Town & Country Planning Act 1990 (as amended)
Town and Country Planning (Development Management Procedure) (England) Order 2015
Approval of details reserved by conditions imposed under P/107/16/PL relating to conditions 3-
surface water drainage, 4-schedule of materials & finishes, 5-landscape scheme, 6-screen
wall/fence details, 8-site set up during construction, 10-storage of waste & recycling details , 11-
placement of 2 No. nesting opportunities for birds & 14-external lighting details.
7 Webb Close Pagham,,

Condition Number 6

Arun District Council have decided to **APPROVE details reserved by this condition**

17017-103^A

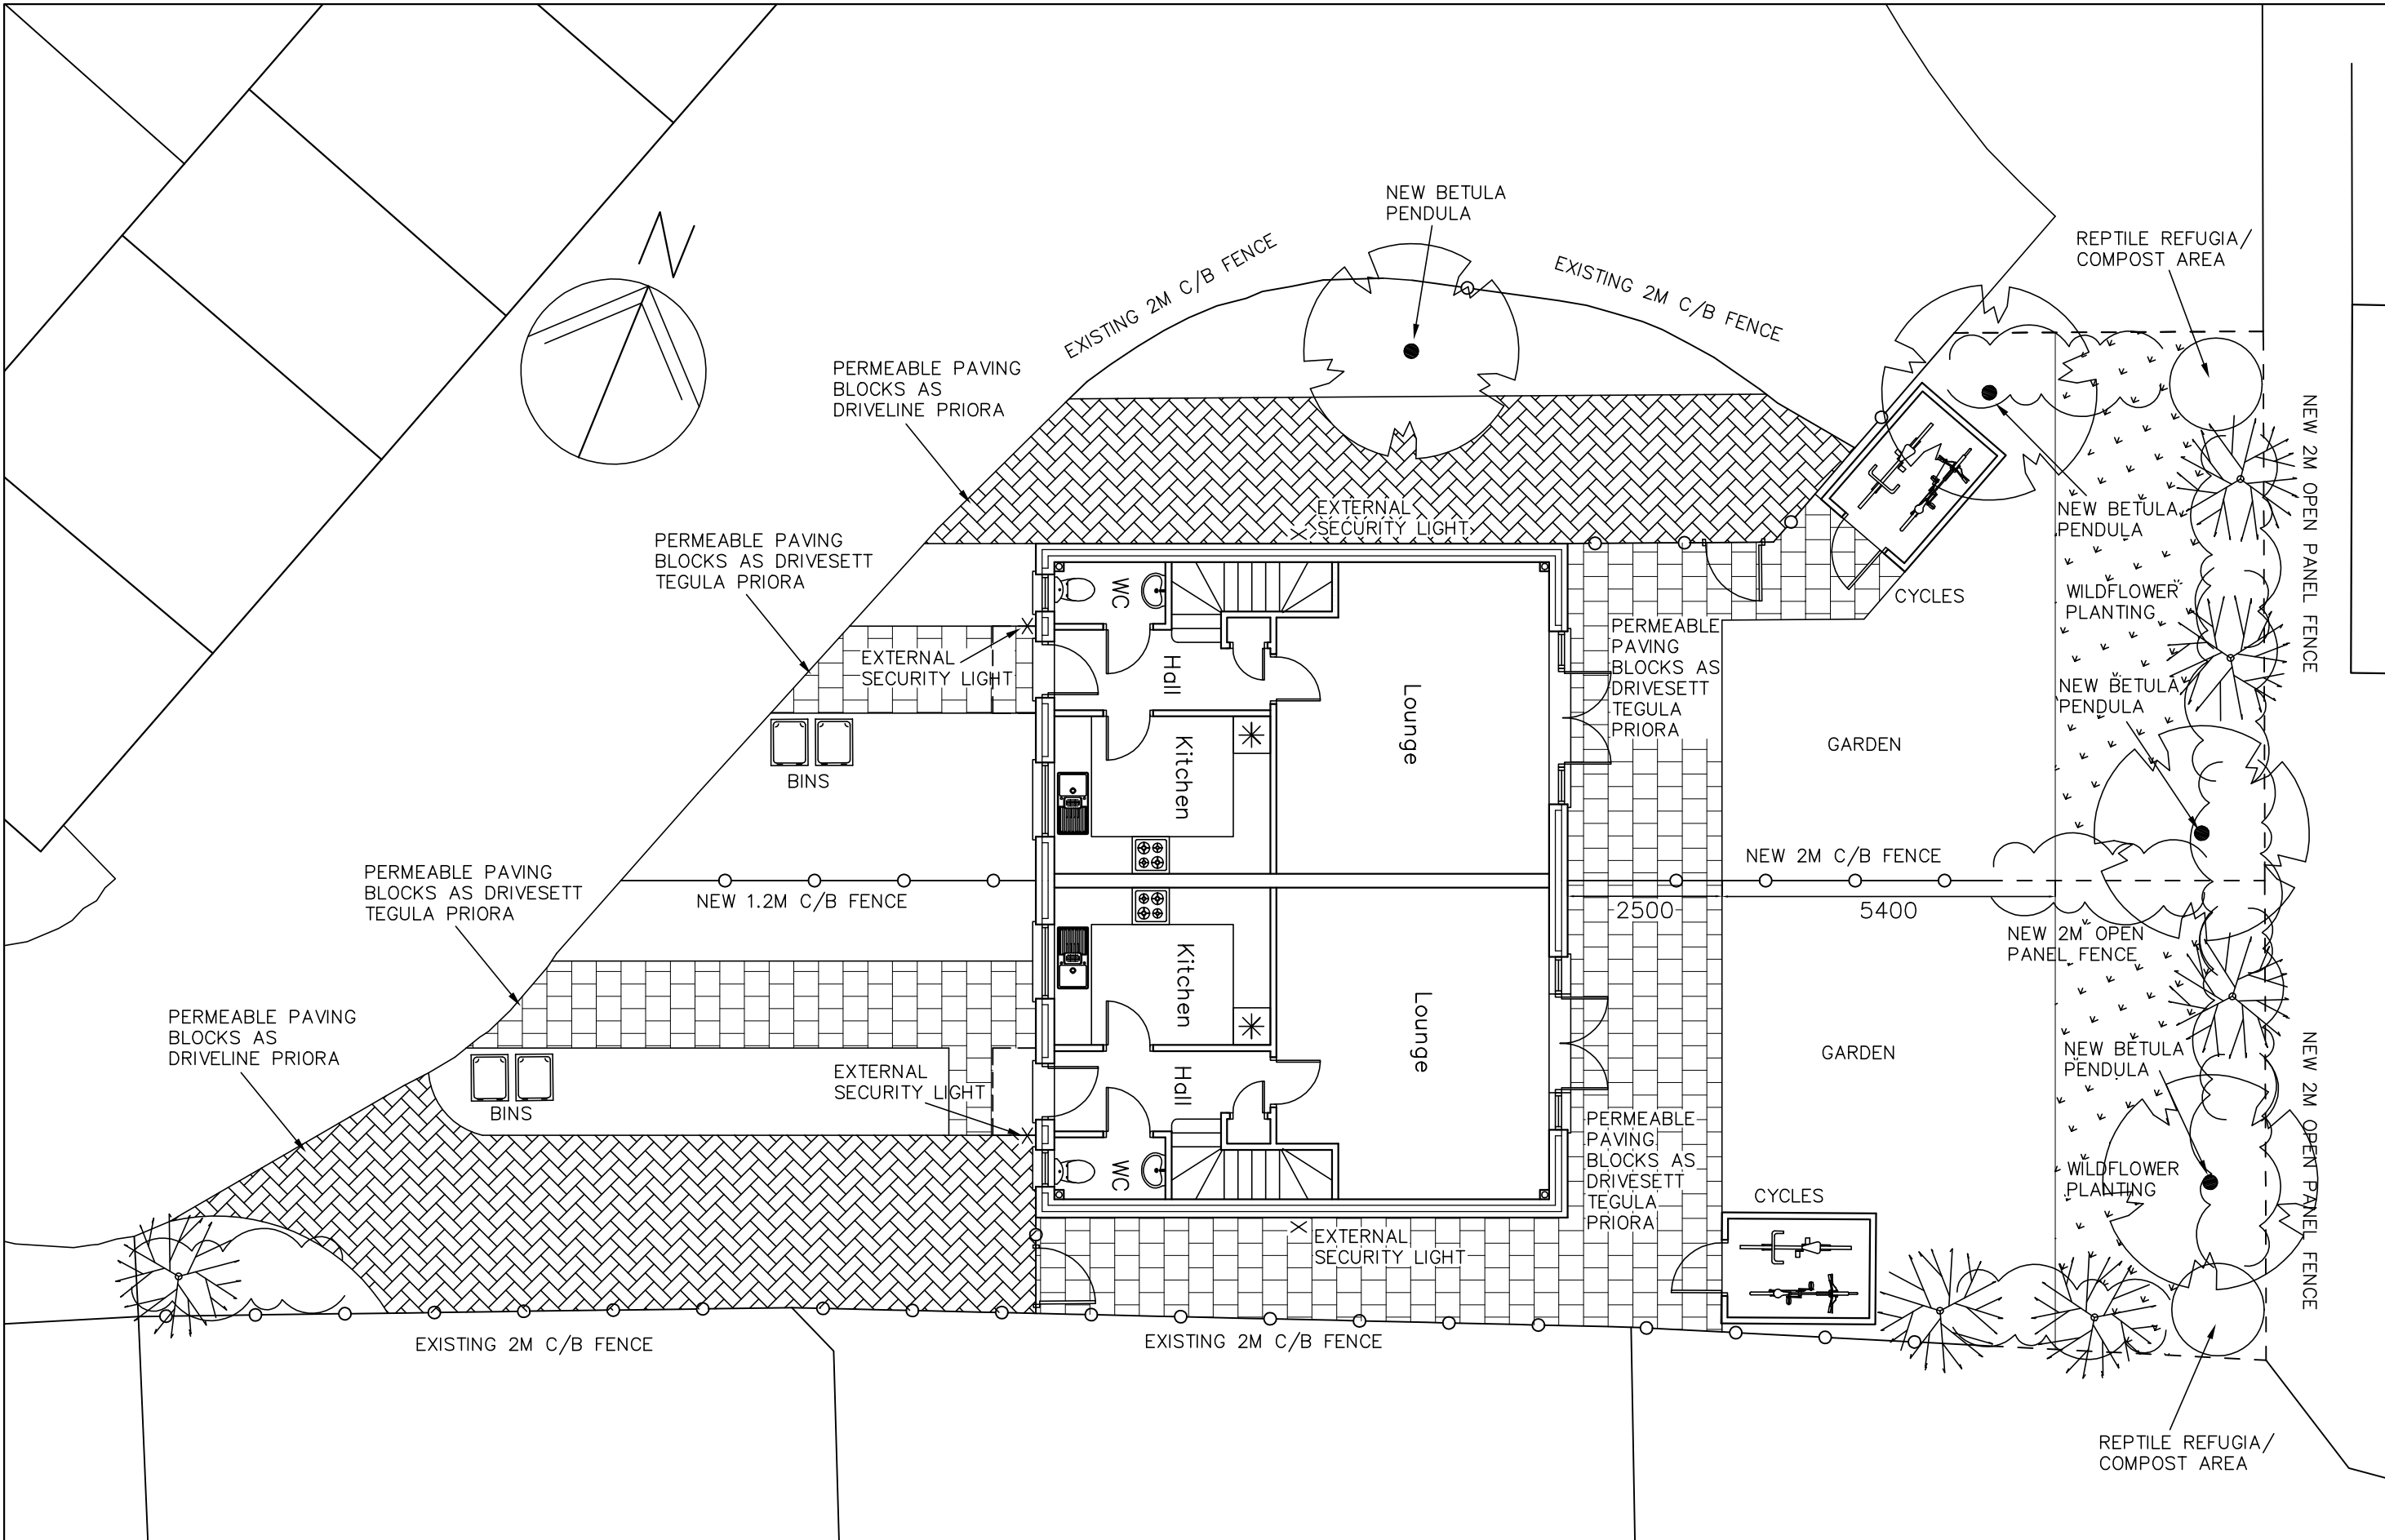
The submitted details in respect of the new boundary between the two dwellings, namely the use of 2m high timber close boarded fencing in the positions as shown on the submitted Site Plan drawing 17017-103 Rev A are considered to provide an acceptable scheme and satisfies the requirements of the condition.

The condition is therefore fully discharged insofar as the submission of details relates and on the understanding that the new fences will be permanently retained.
